Office of  
Environment  
& Heritage

DOC19/35105  
SSD9606

**Notice of Exhibition - Building D14 Redevelopment, University of New South Wales (SSD 9606)**

## **Attachment 1 – Office of Environment and Heritage (OEH) comments - Exhibition of Building D14 Redevelopment, University of New South Wales**

Project No.	Drawing No.	Revision
18026	ADDA20M00	05

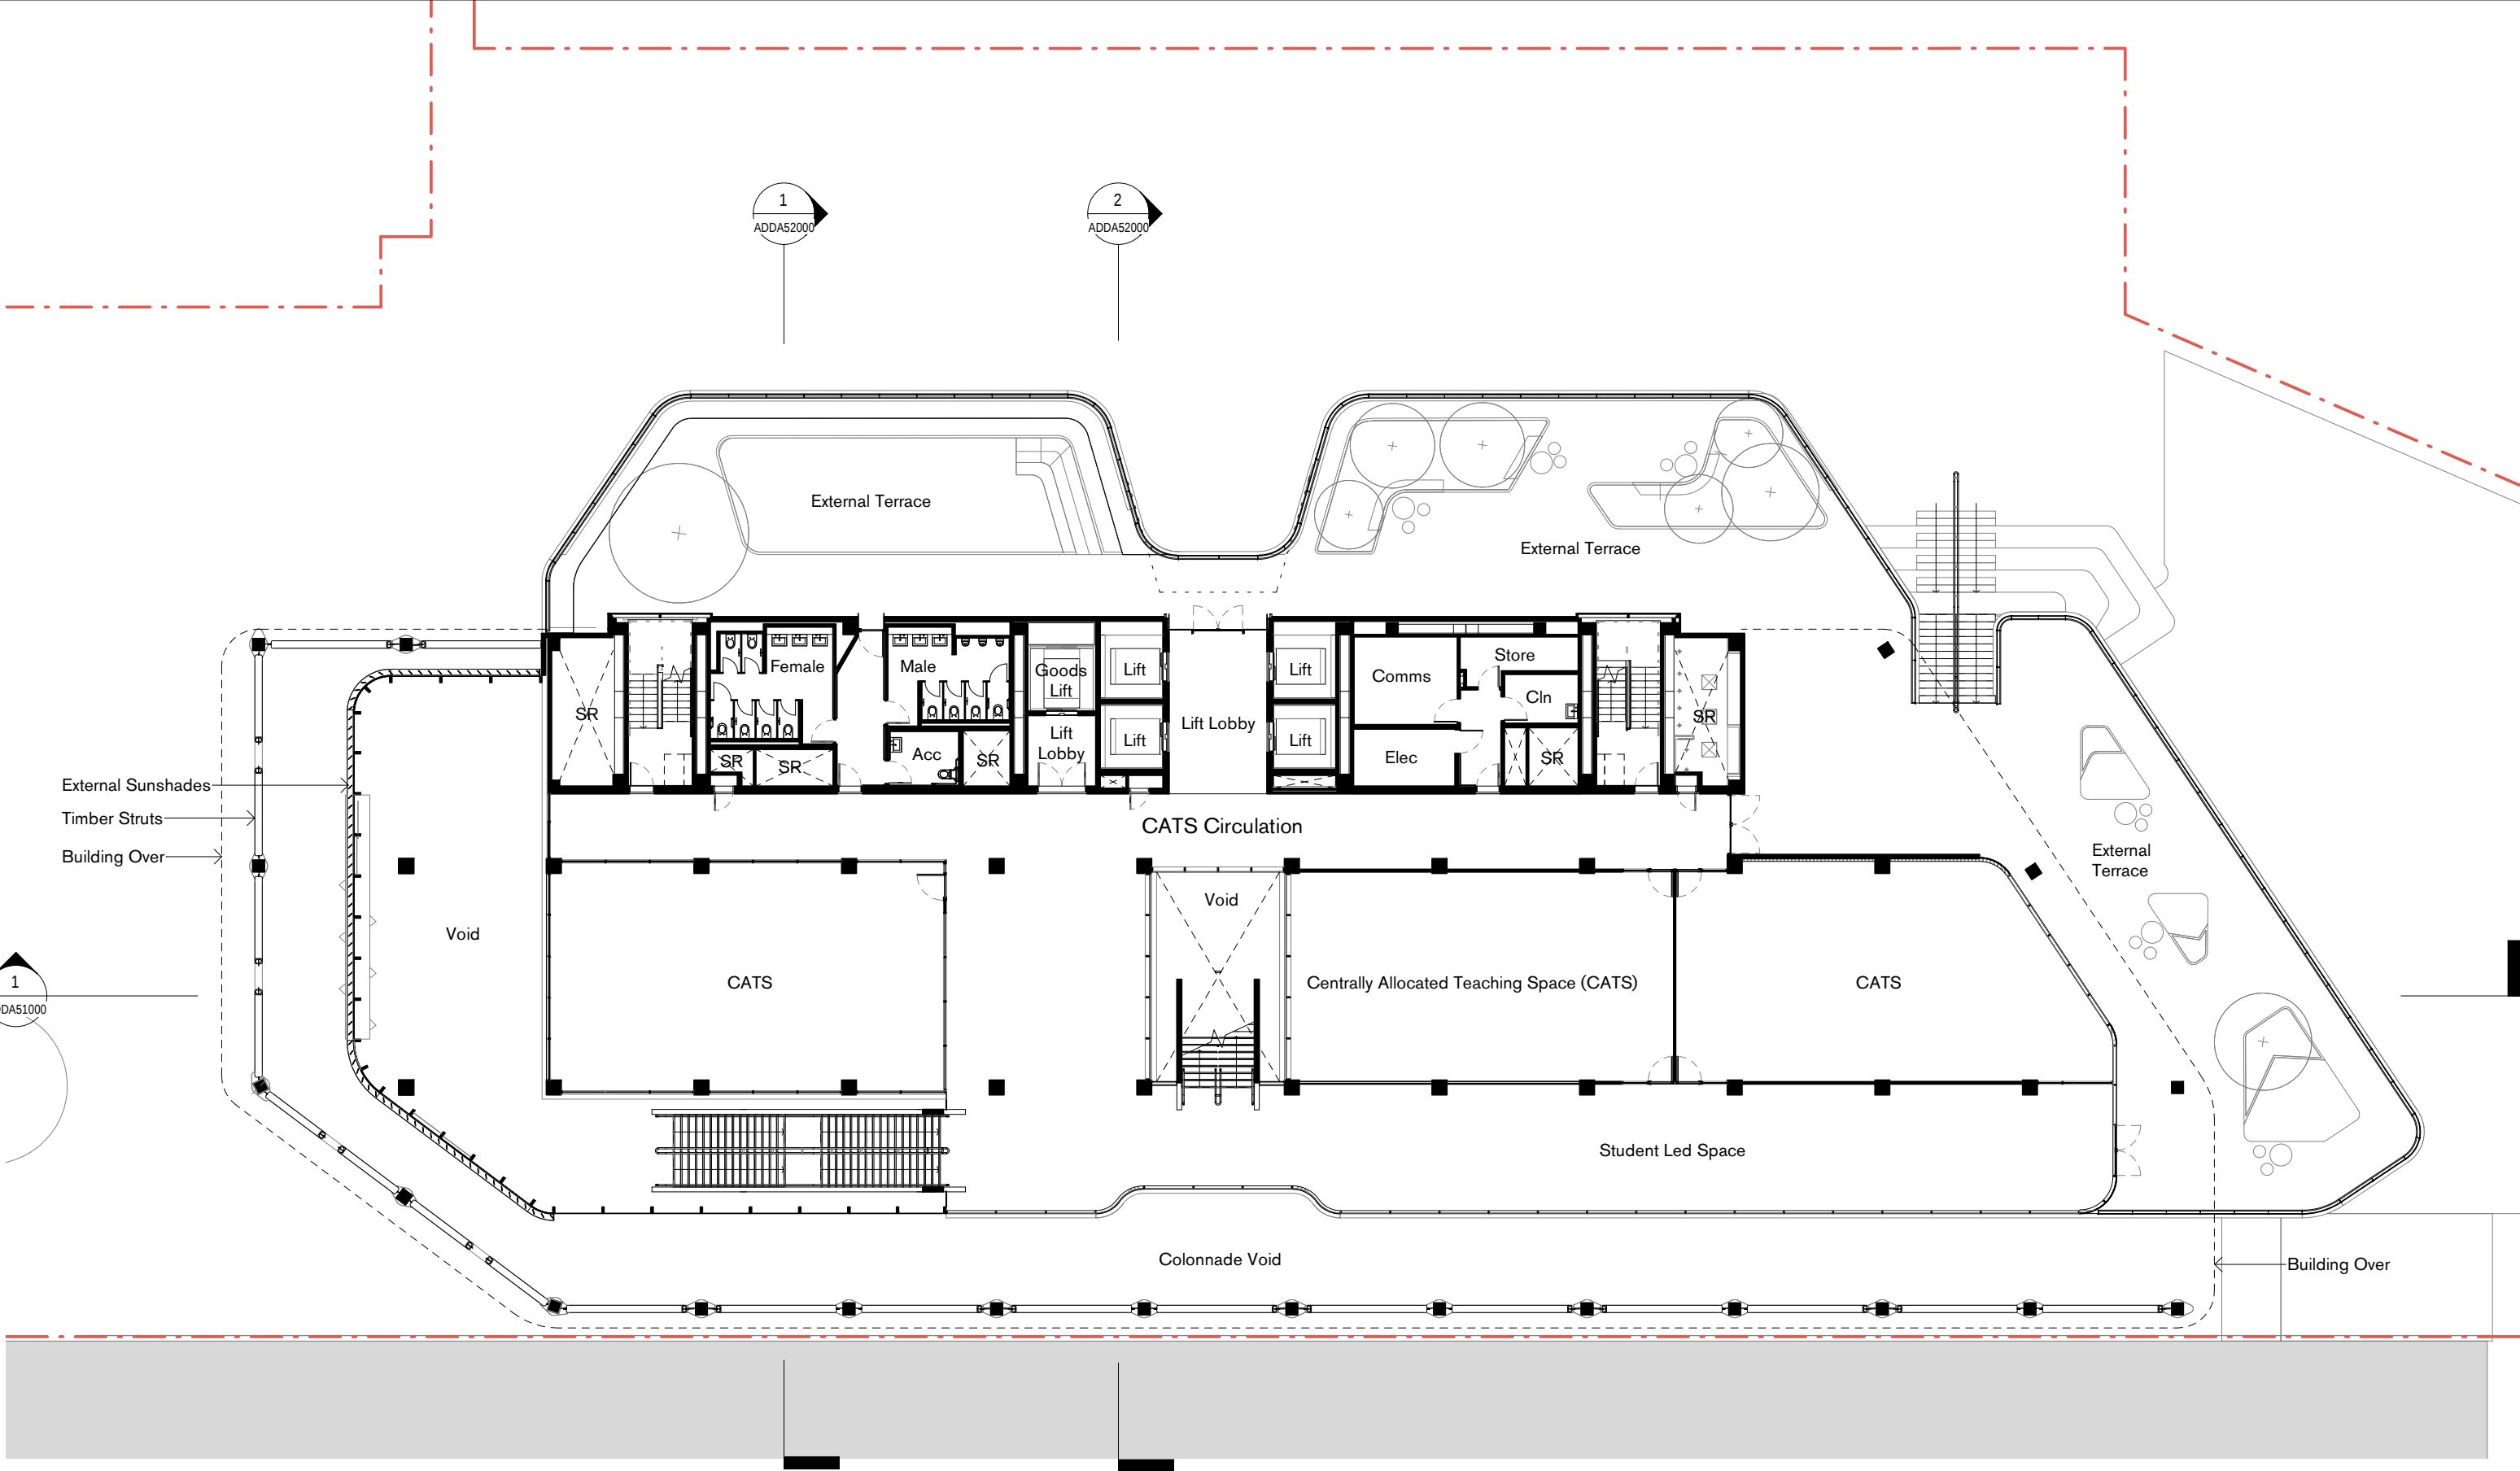
Additional tree canopy cover and green cover opportunities could be achieved in the following areas of the building and public domain areas including:

- the Level 1 Landscape Works and terraces that provide large open breakout spaces and present an opportunity for additional green areas
- Fig Tree Courtyard space and Whitehouse Bleachers: replace stone or concrete with green cover areas, and
- Alumni Terrace: grassed terraced seating area would better integrated with the alumni passive open space area.
